North Lincolnshire Council answers to the Examining Authority's first set of written questions for the VPI Immingham OCGT Project

Drawing Title
**VIEWPOINT LOCATION PLAN
FIGURE 10.4**

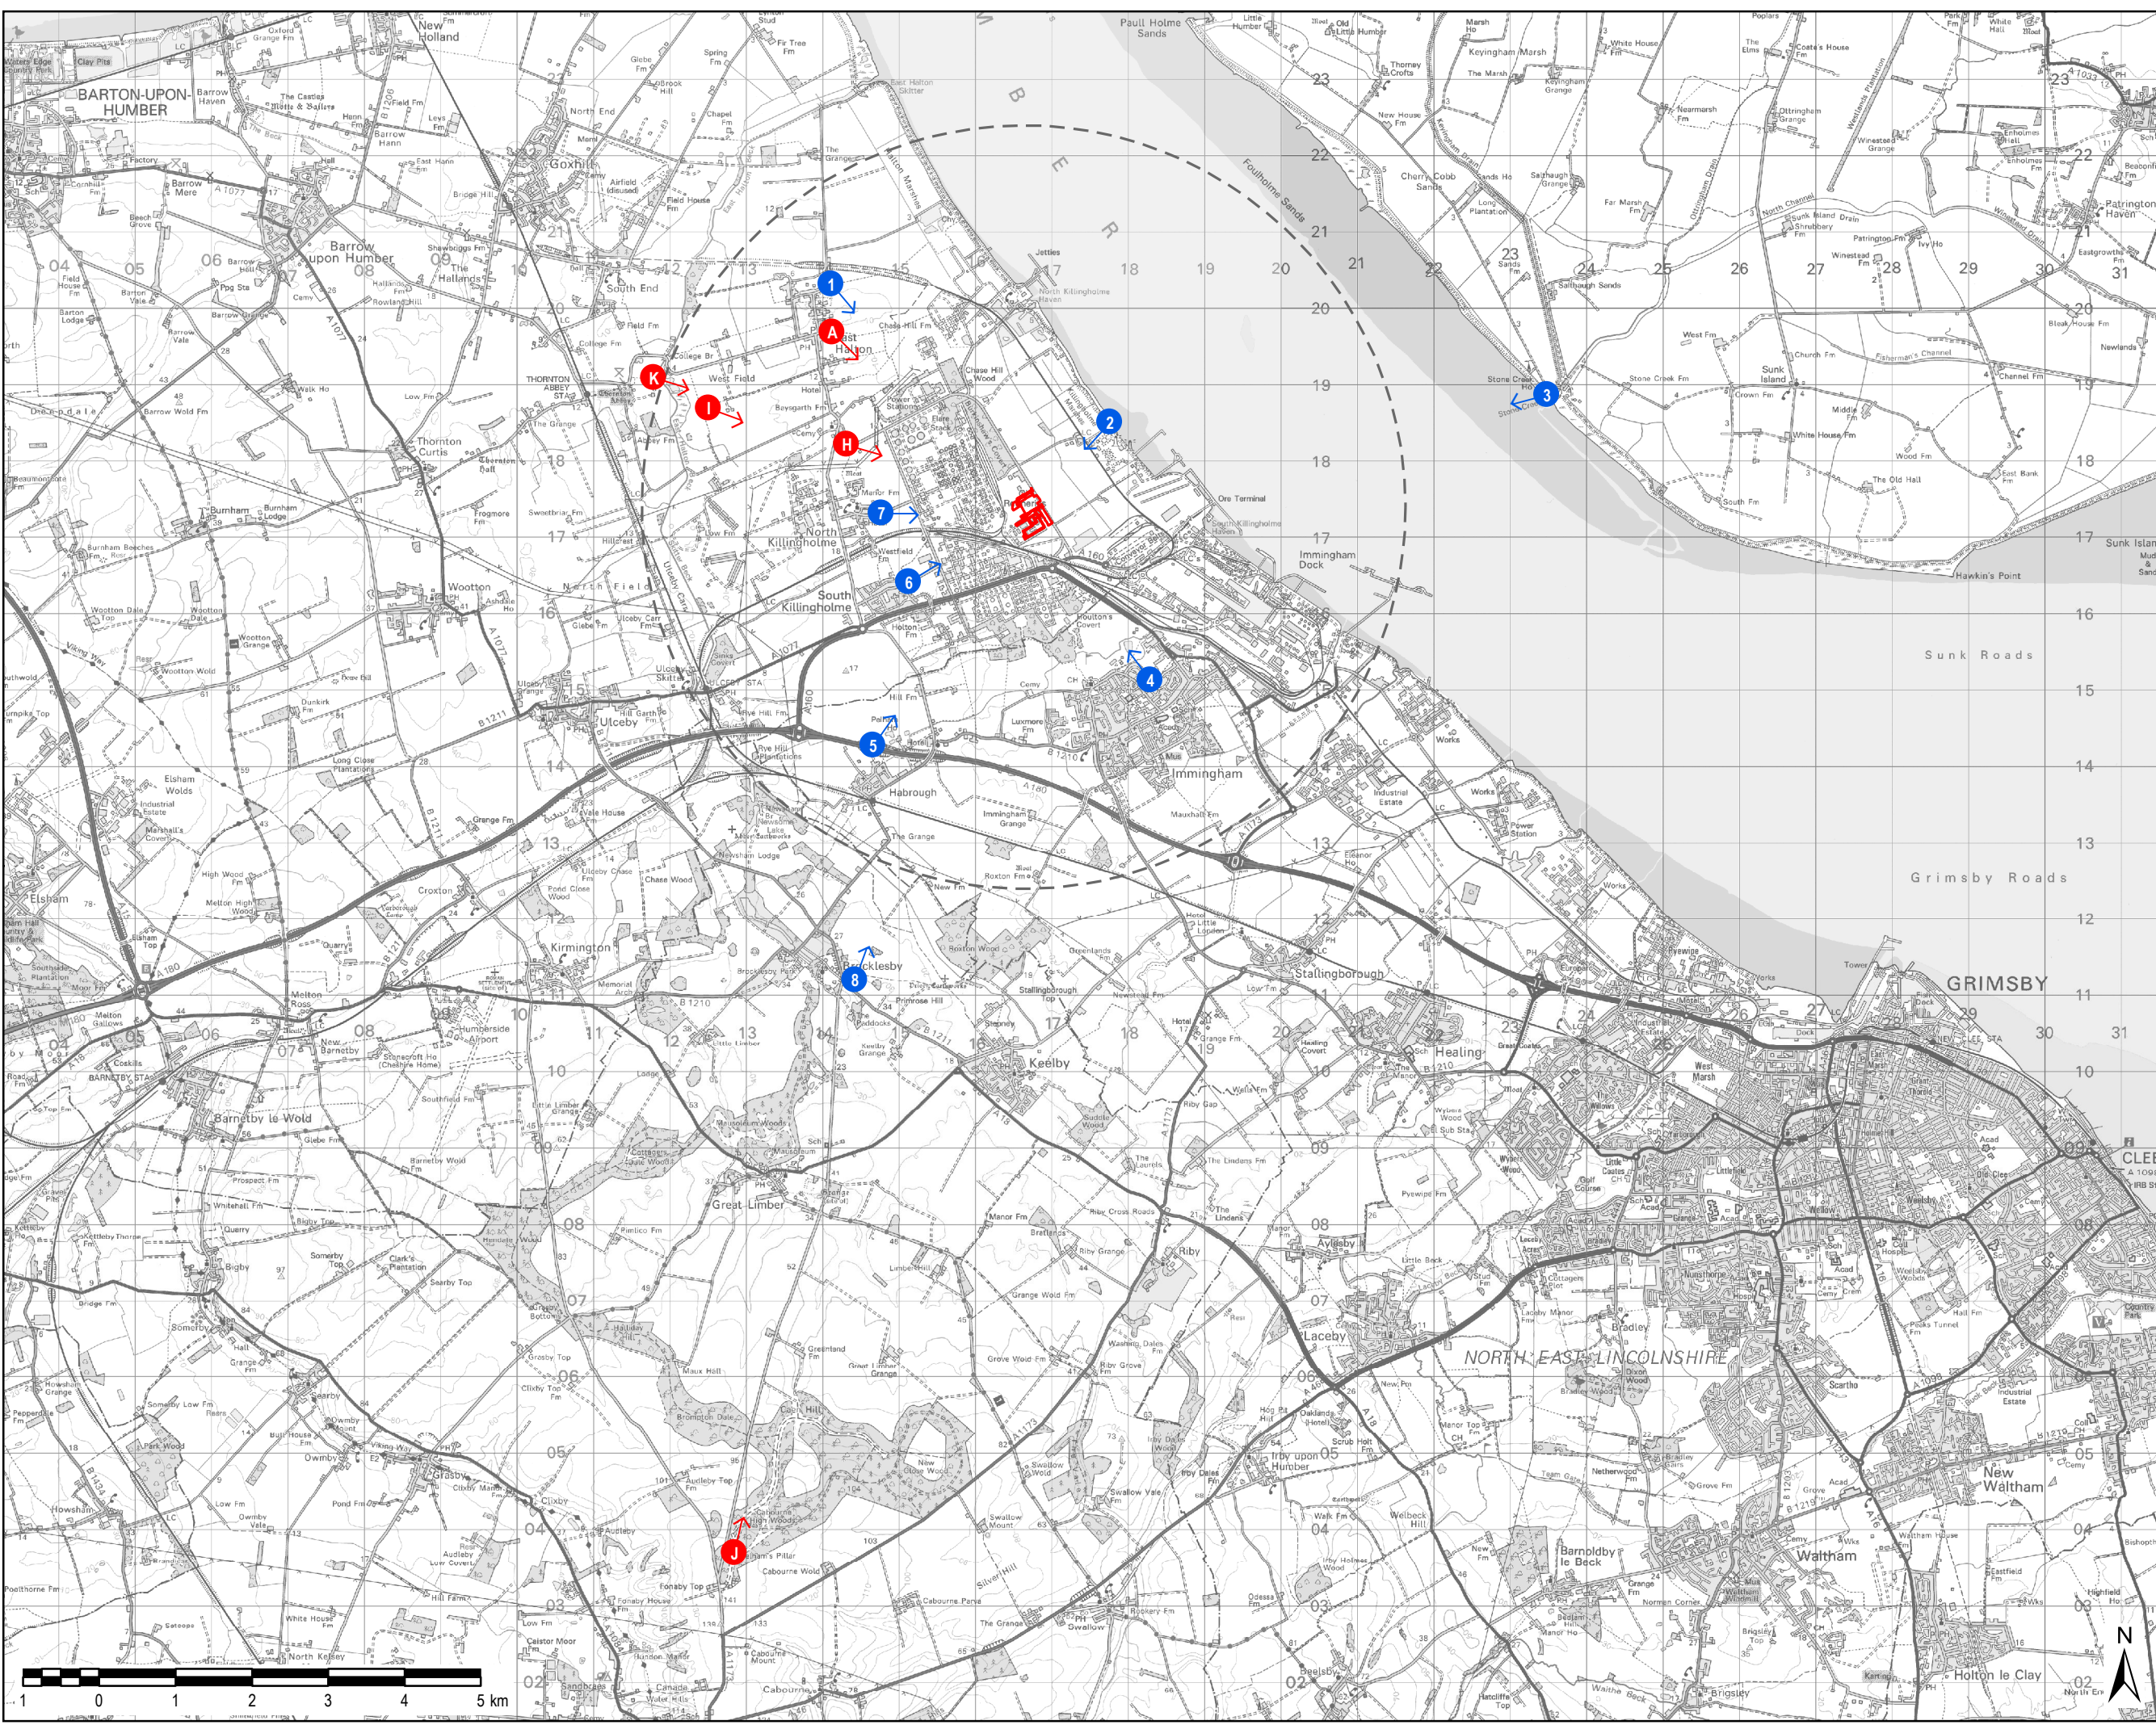
NLC confirm that the viewpoints are appropriate and provide reasonably representative views of the proposed development.

The only addition that NLC feel should be considered is would make is the proposed England Coast Path. If the Able Marine Energy Park project goes ahead, the Coast Path (a National Trail) is likely to “roll back” to Rosper Road. Rosper Road would therefore provide key viewpoints for users of the National Trail.
